**THE SIZEWELL C PROJECT**

**EN010012**

## **SUMMARY OF WRITTEN REPRESENTATION:**

**Harmful effects of the proposed new Access Road on designated sites and protected wildlife**

DRAWING NO: SZC-SZ0100-XX-000-DRW-100205	REVISION: 02
DATE: JULY 2021	DRAWN: CGK
	SCALE: AS SHOWN @ A1

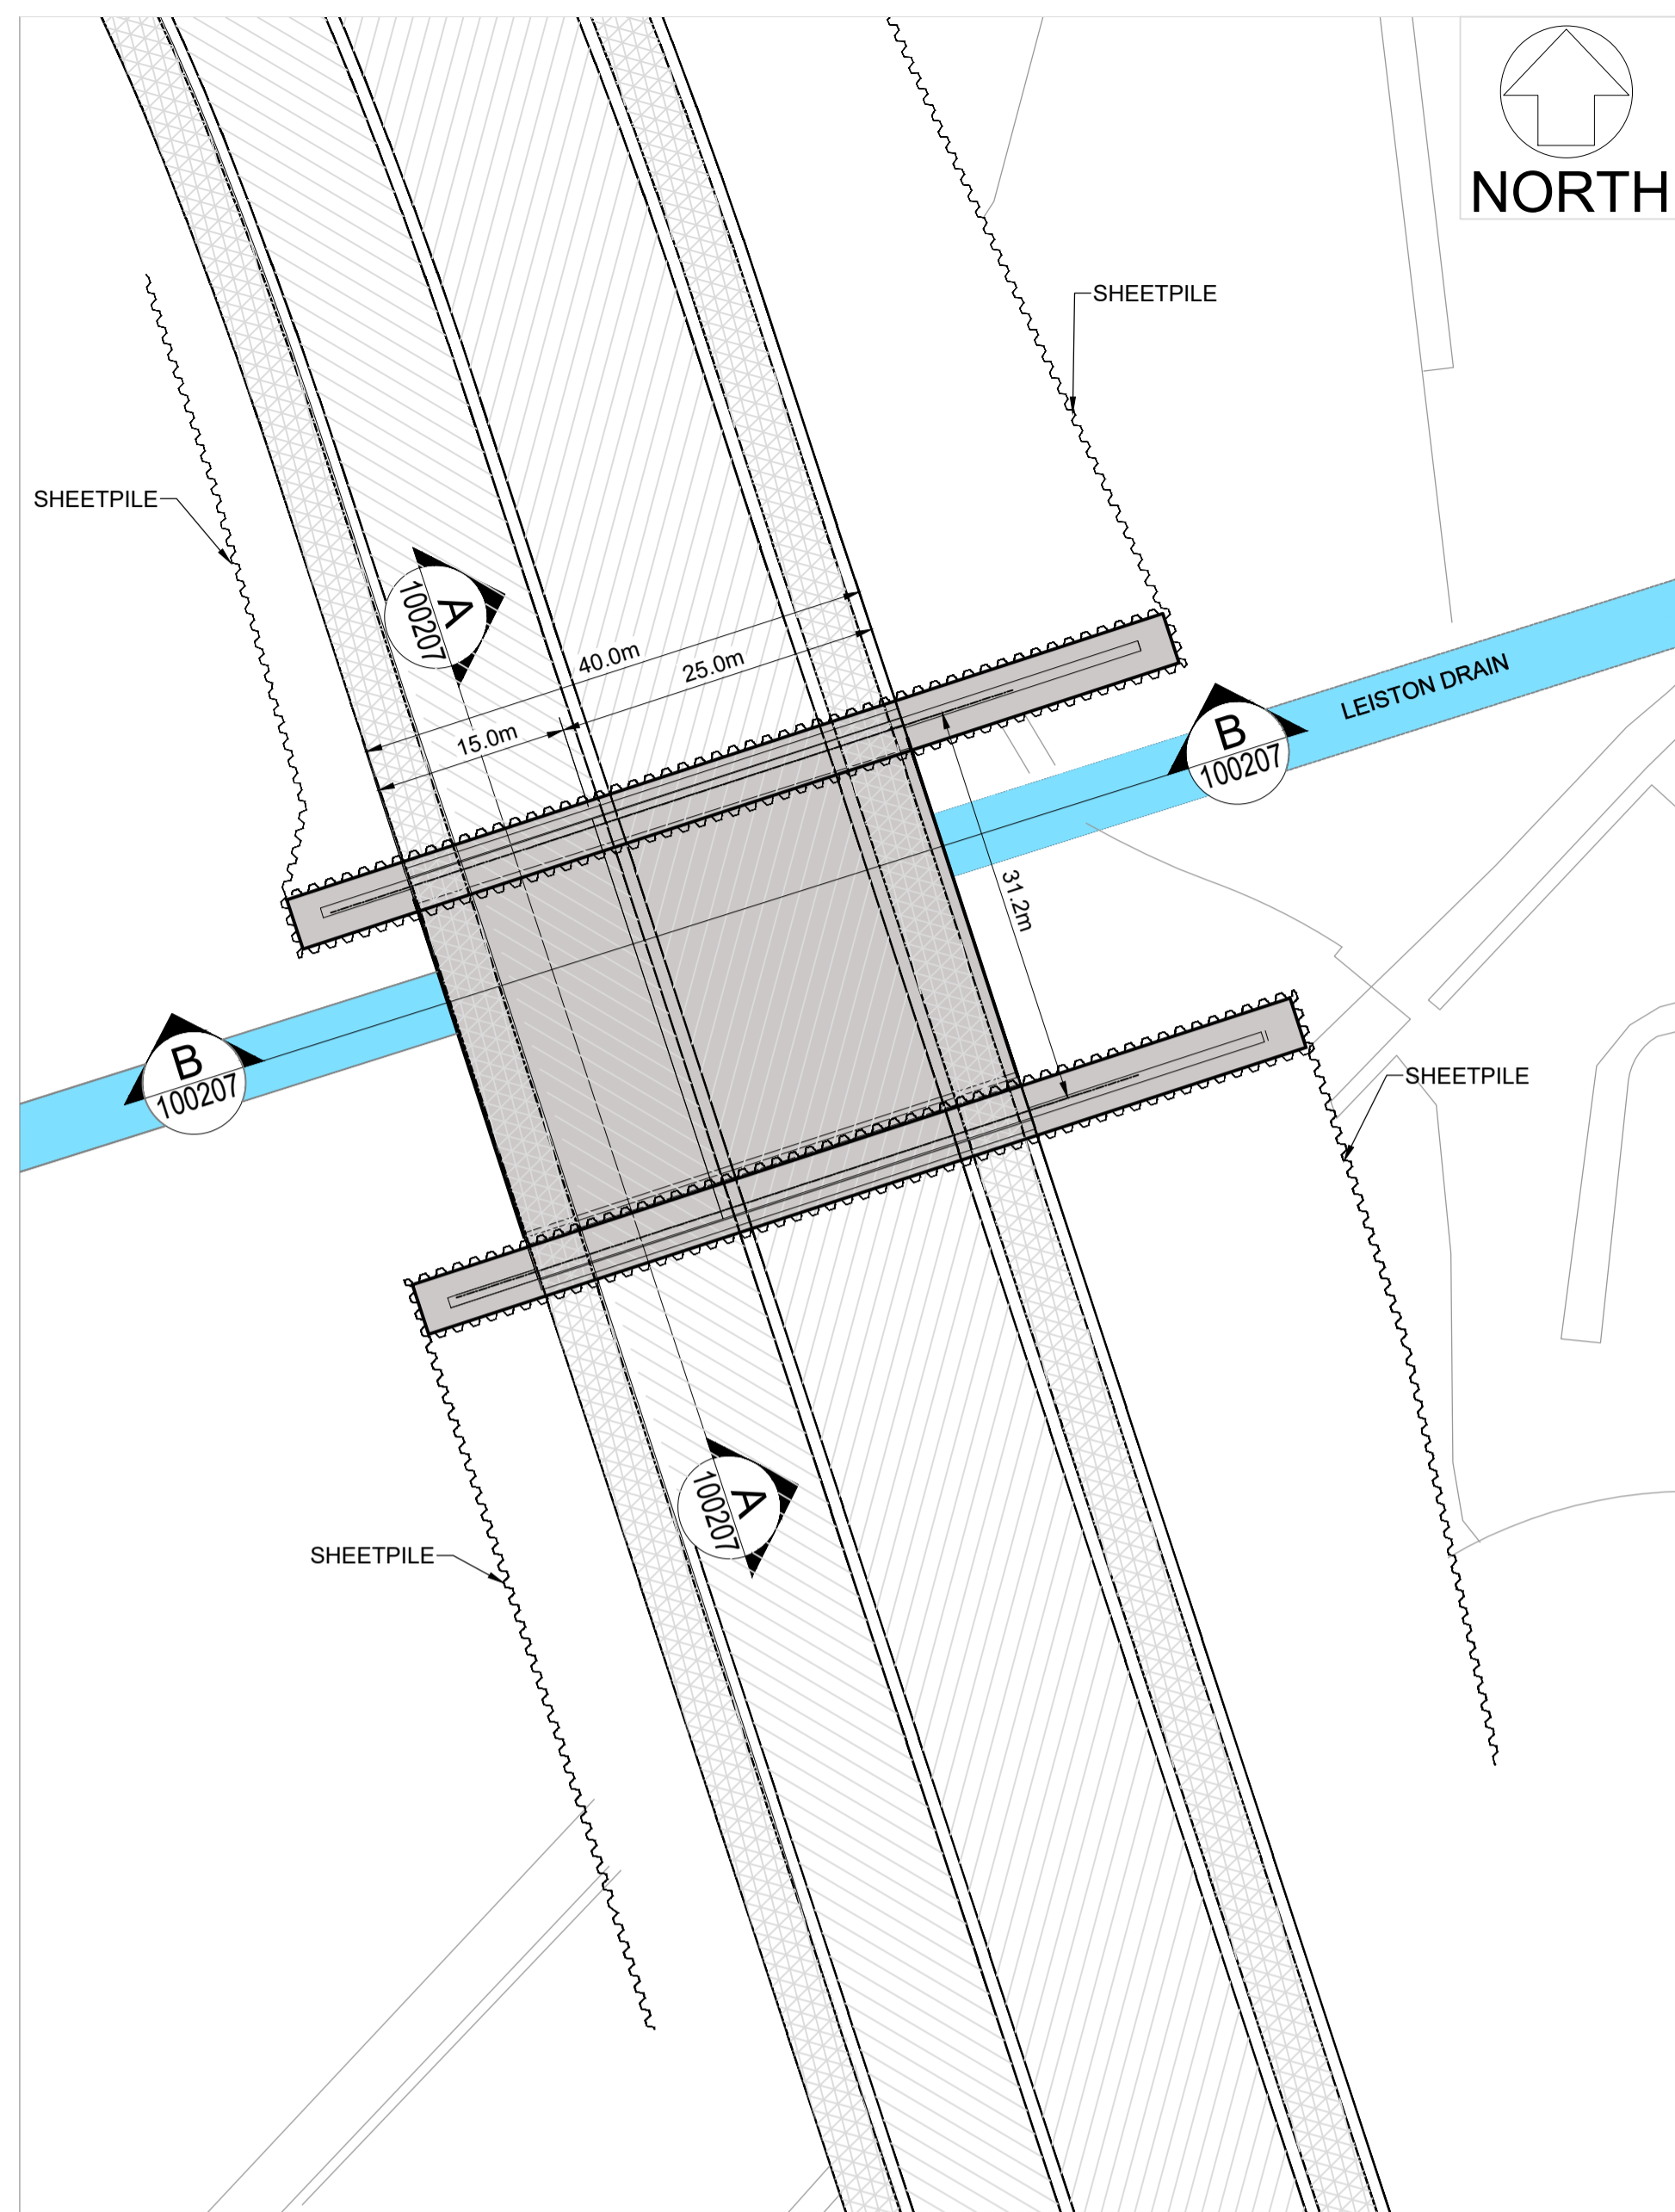
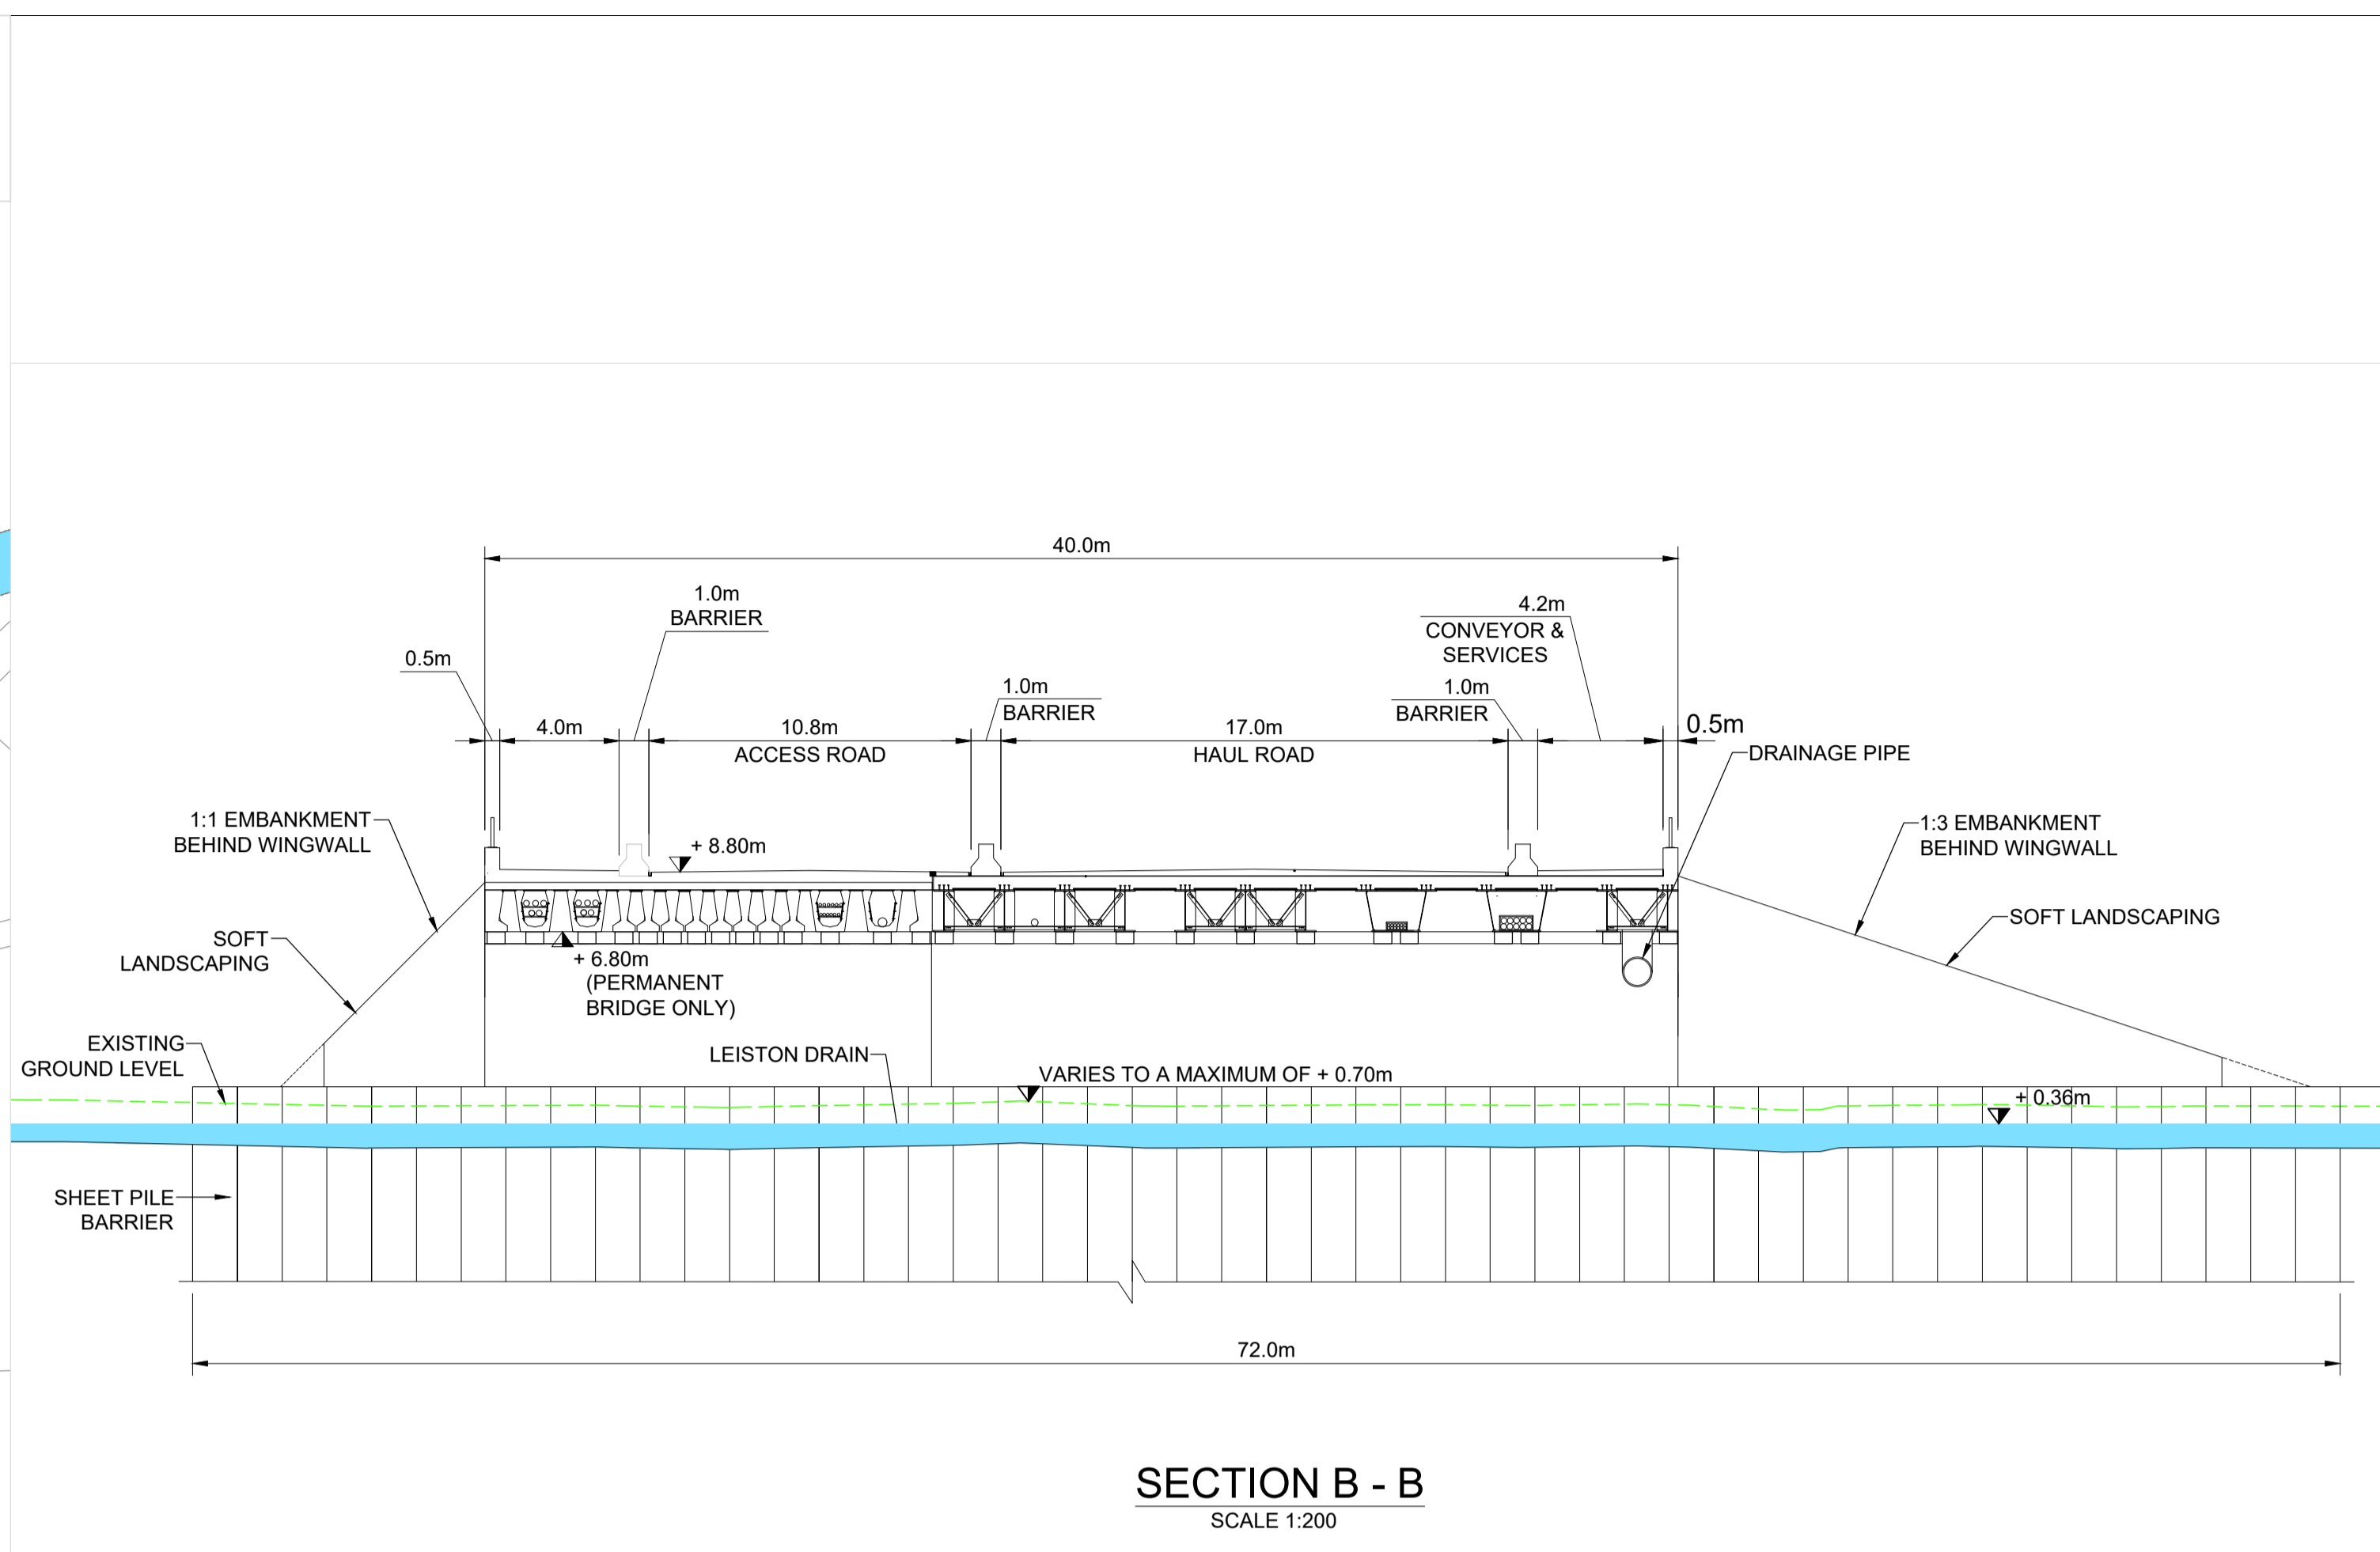
- The Access Road would create a permanent barrier to the movement of wildlife between the designated sites of Sizewell Marshes SSSI and Minsmere-Walberswick SSSI, SAC, SPA and Ramsar. The Minsmere sites are functionally linked to Sizewell Marshes SSSI, where important foraging ground is offered for birds and animals. The only possible access north to south would be beneath the SSSI Crossing, which many

animals would not use due to its length and darkness and the marshiness of the surrounding land. This reduces the possibility of dispersal to find mates, with populations either side thereby becoming genetically weakened.

- This SSSI Crossing, with dark tunnel and culvert beneath, at 47m in length, would create a dead zone in the central portion of Leiston Beck/Drain (small river), the main drainage route to the north, causing chronic ecological damage, including loss of rare aquatic invertebrates, harm to fish, and affecting the designated Minsmere-Walberswick sites to the north and east, through which it flows.

**Plate 1.20: Indicative lighting model for SSSI crossing**

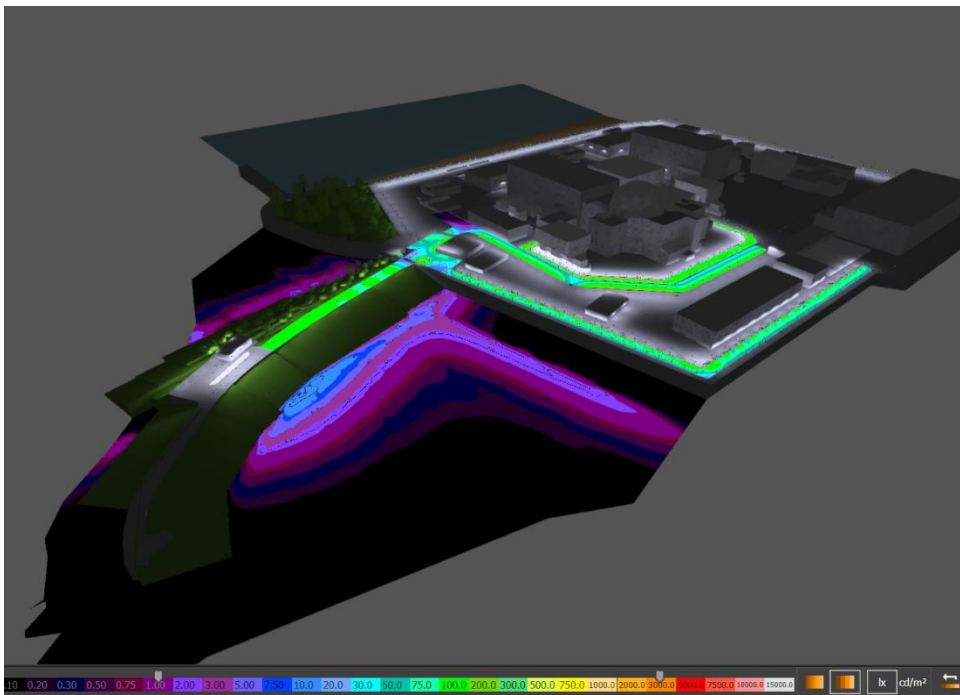
- Security lighting would remain after construction at various points along the road, exposing many species to predators. This would be extremely disorientating to bats and reduce their foraging ability, especially where the road dissects their established commuting routes. Reduction in bat populations are anticipated up to 1.6km either side of the road. Some bat species present are rare, including the Barbastelle.
